City of Portland, Maine - Building or Use Permit Application

Location of Construction: 348 Palmer Ave	Owner Name: Viola Patrick R Iii &	Owner Address: 386 Palmer Ave	Phone:
Business Name:	Contractor Name: Steve Brann	Contractor Address: 39 South Freeport Freeport	Phone: 2078656674
Lessee/Buyer's Name	Phone:	Permit Type: Additions - Dwellings	Zone: R-2

Past Use: Single Family Home	Proposed Use: Single Family Home/ Build room over garage/ home renovations	Permit Fee: \$372.00	Cost of Work: \$38,500.00	CEO District: 5
---------------------------------	---	-------------------------	------------------------------	--------------------

From: "Andy Fillmore" <afillmor@maine.rr.com>
To: <tmm@portlandmaine.gov>
Date: Wed, Jun 15, 2005 3:25 PM
Subject: Viola Residence, 386 Palmer Ave.

PROPOSED GARAGE STRUCTURAL DETAIL

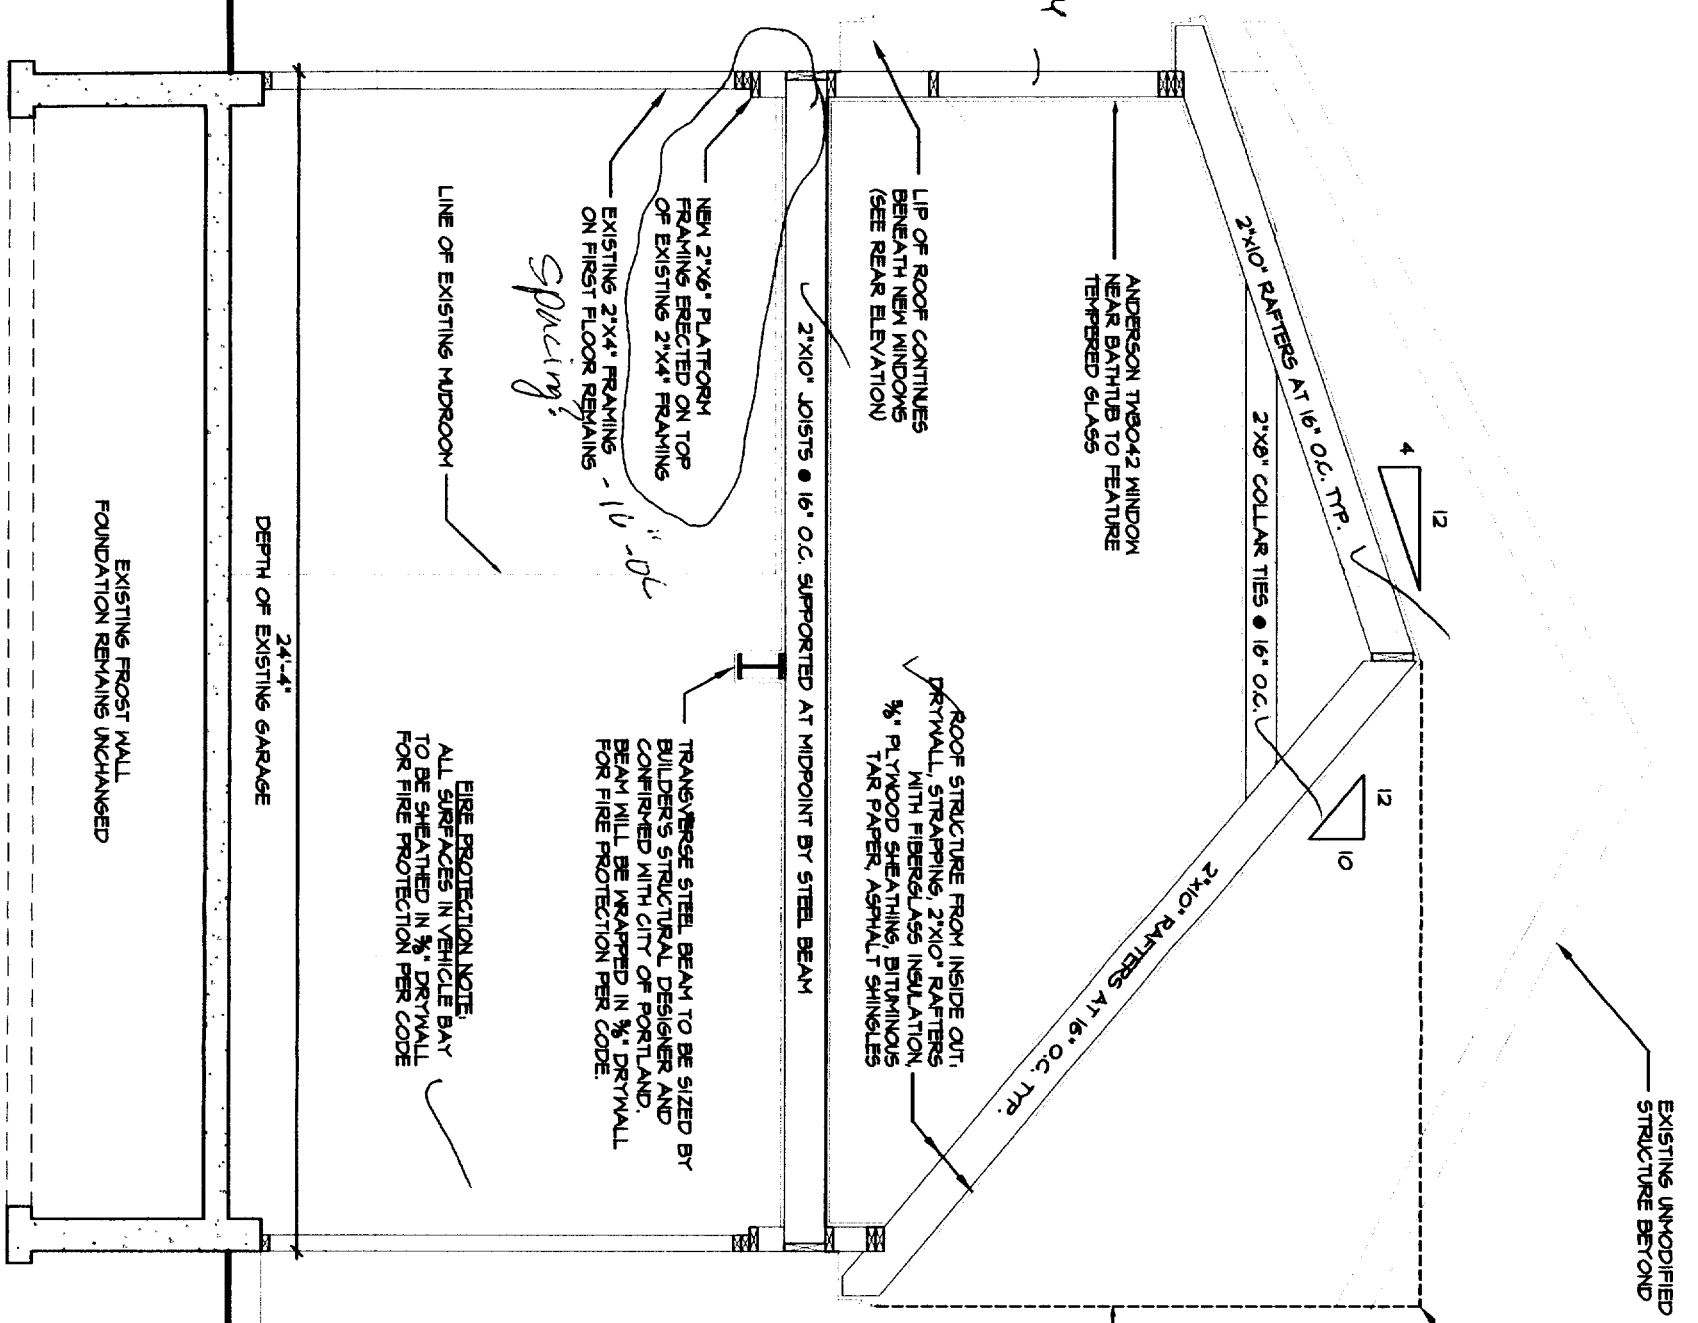
Also attached is a drawing that changes the 2"x6" kneewall to a 2"x4" kneewall to match the first floor framing, as you requested.

2"x6" KNEEWALL ON TOP OF EXISTING
FIRST FLOOR FRAMING HAS BEEN CHANGED
TO BE A 2"x4" KNEEWALL PER DIRECTION
OF CITY OF PORTLAND

**Roof Plan,
Framing Plan,
Window Sched.**

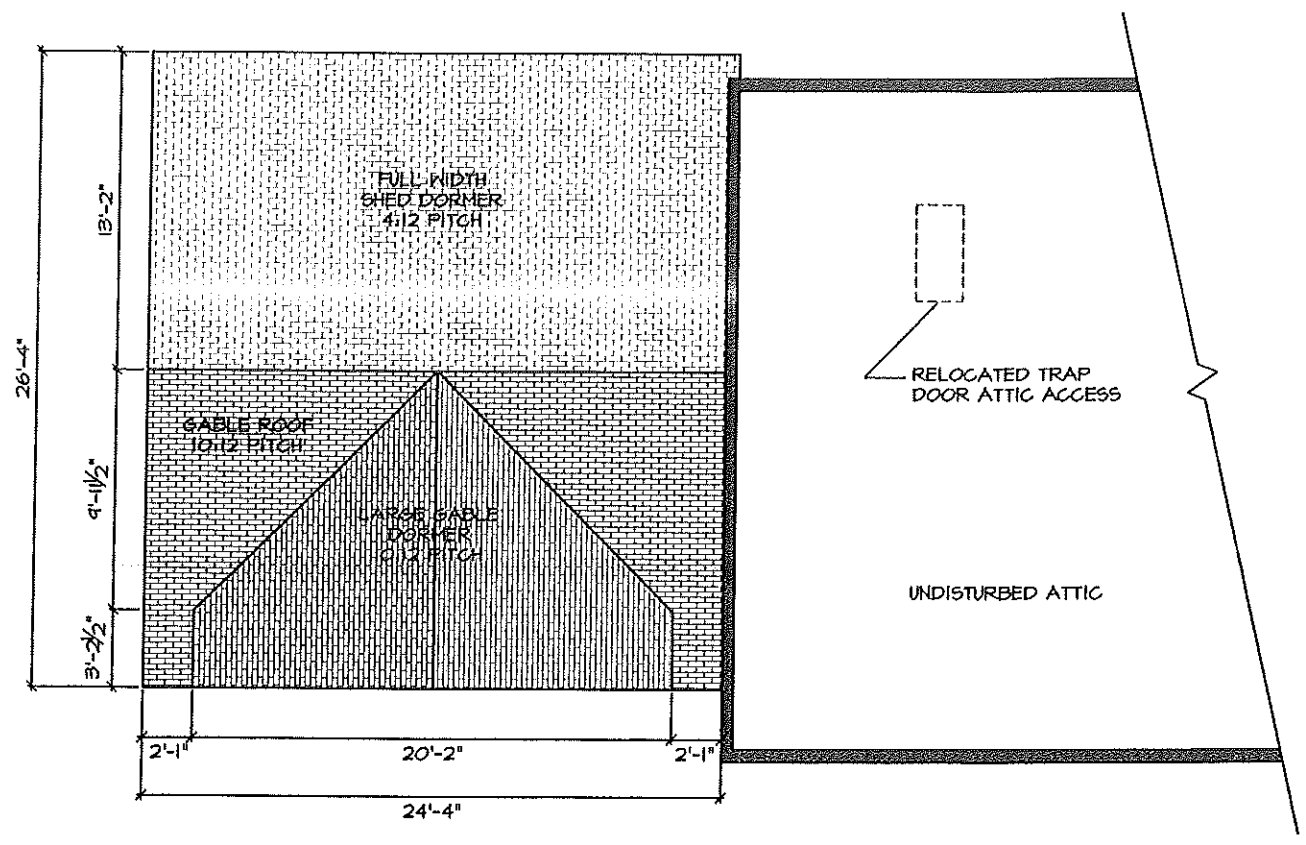
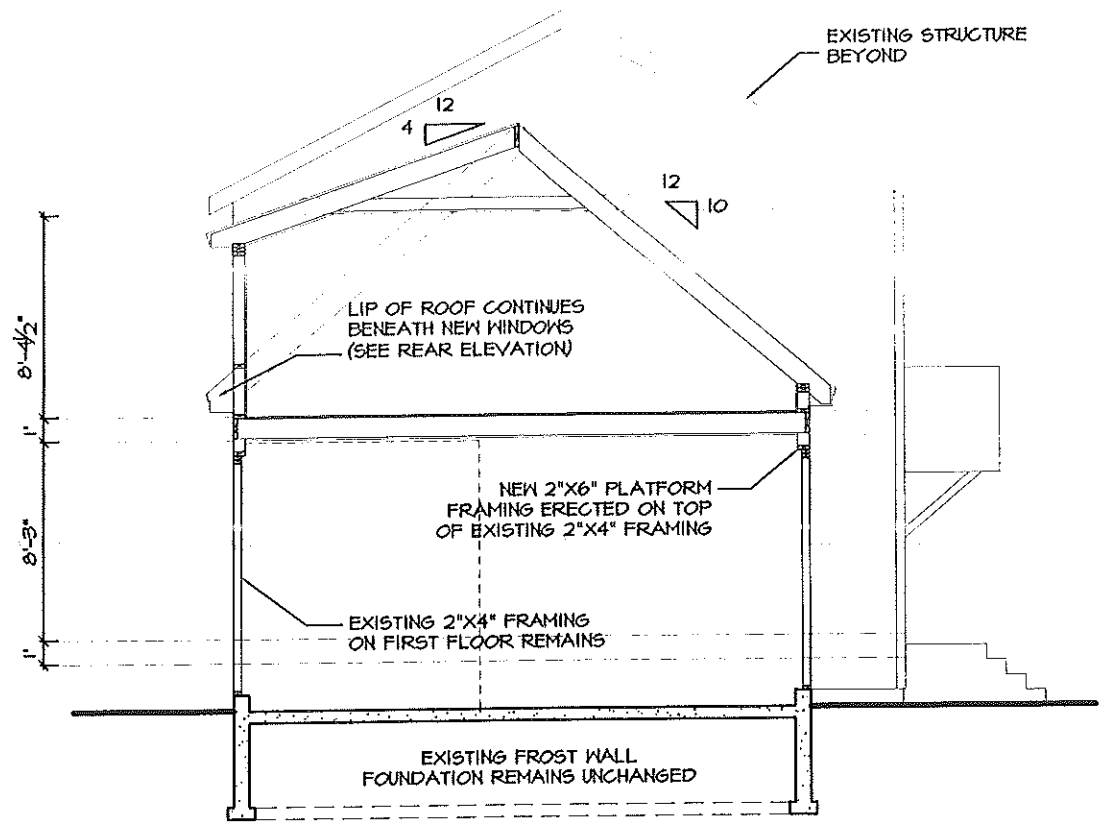
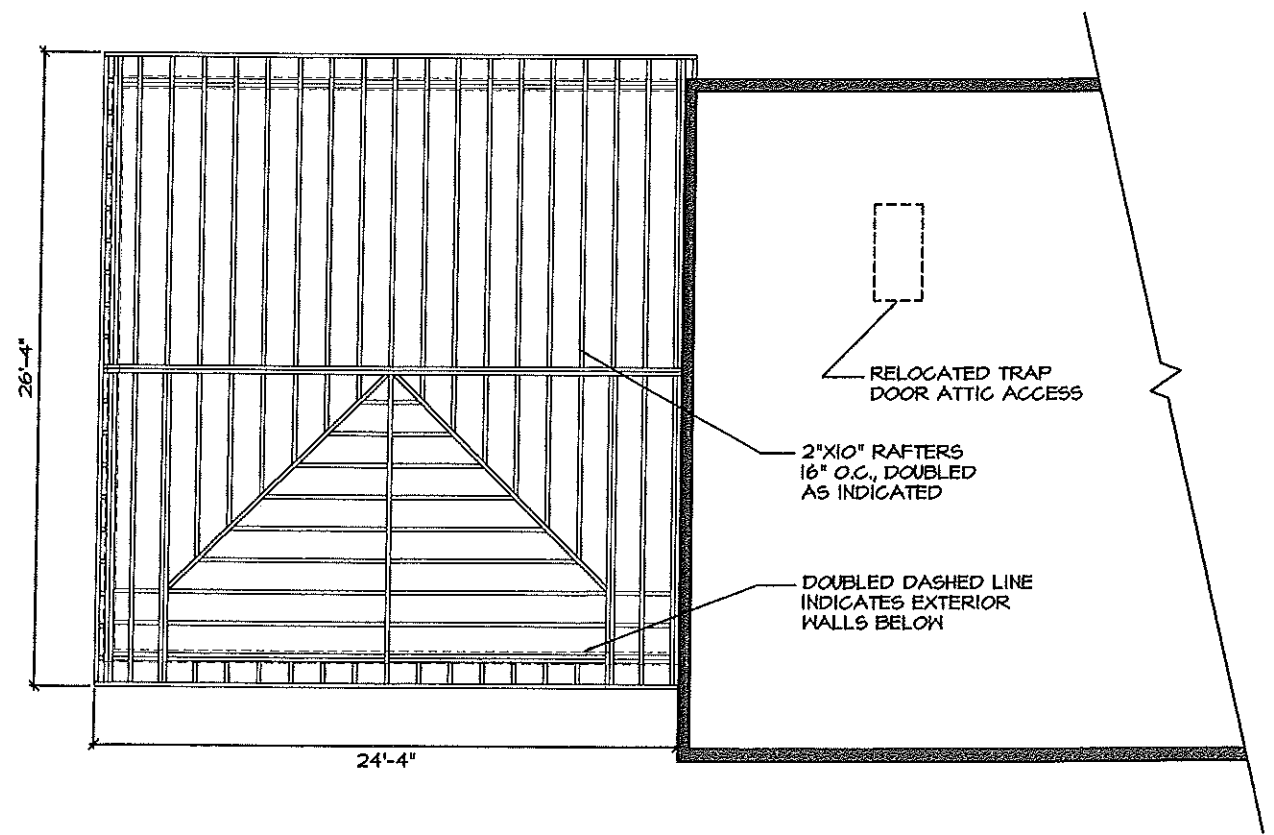
Dept: Building	Status: Approved with Conditions	Reviewer: Tammy Munson	Approval Date: 06/17/2005
Note:	Ok to Issue: <input checked="" type="checkbox"/>		
1) The design load spec sheets for any engineered beam(s) must be submitted to this office. 2) Permit approved based on the plans submitted and reviewed w/owner/contractor, with additional information as agreed on and as noted on plans. 3) Separate permits are required for any electrical, plumbing, or heating.

Thanks for your call today. I just spoke with the builder, Steve Brann, and got the info on the headers. I have pasted the window schedule from Drawing #10 the drawing set into this e-mail, and have added the header info for each window.

WINDOW / HEADER SCHEDULE:

1. QTY: 1 ANDERSON TW3042 R. O. = 3'-2-1/8"w X 4'-4-7/8"h ✓

Header = 3 of 2"x6", length to span rough opening and bear on jack studs.

2. QTY: 1 ANDERSON TW3046-2 R. O. = 6'-3-15/16"w X 4'-9-1/4"h ✓

Header = 2 of 2"x10", length to span rough opening and bear on jack studs.

3. QTY: 1 ANDERSON TW3042-3 R. O. = 9'-5-3/4"w X 4'-5-1/4"h ✓

Header = 3 of 2"x6" bearing on vertical studs between window units and jack studs at ends.

4. QTY: 1 ANDERSON P3030 R. O. = 3'-0-1/2"w X 3'-0-1/2"h

Header = 2 of 2"x8", length to span rough opening and bear on jack studs. ✓

5. QTY: 2 CLERESTORY WINDOWS OVER 9'w GARAGE DOORS

TO BE CHOSEN BY OWNER & BUILDER. ✓

Header = 2 of 11-7/8" L.V.L.s, length to span rough opening and bear on jack studs.
